Subject: RE: Planning Consultation on: F/11/20/DOC

Engineers Comments Regarding Surface Water Drainage

Application No: F/11/20/DOC

Site Address: 49 Johnson Way Ford BN18 0TS

MGS -- F/17/19-rev02

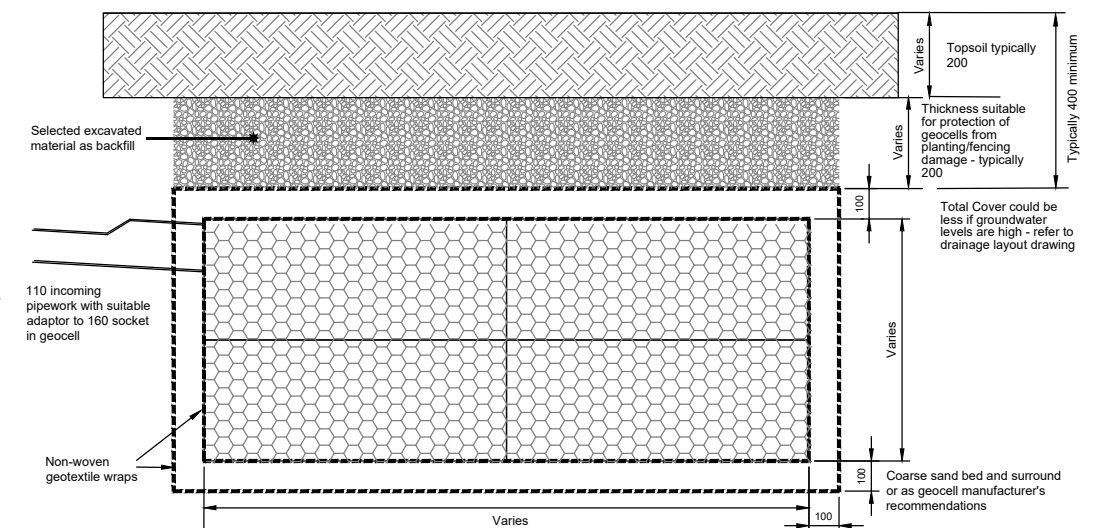
1. The design allows for infiltration through the base. We would normally allow this for a 'blanket' solution, i.e. one crate depth, or where the infiltration rate is worse than silt. Neither of which are the case here. The calculations need to be amended to allow infiltration through the sides only.
2. Please provide a construction detail for a concrete pipe bed and surround for where pipe depths are less than 900mm. Plus amend note as to when each surround should be used (Granular where cover to crown is greater than 1200mm in vehicular areas, or greater than 900mm elsewhere. For shallower depths concrete surround.)
3. Please provide a construction detail for the inspection chamber (no sump).
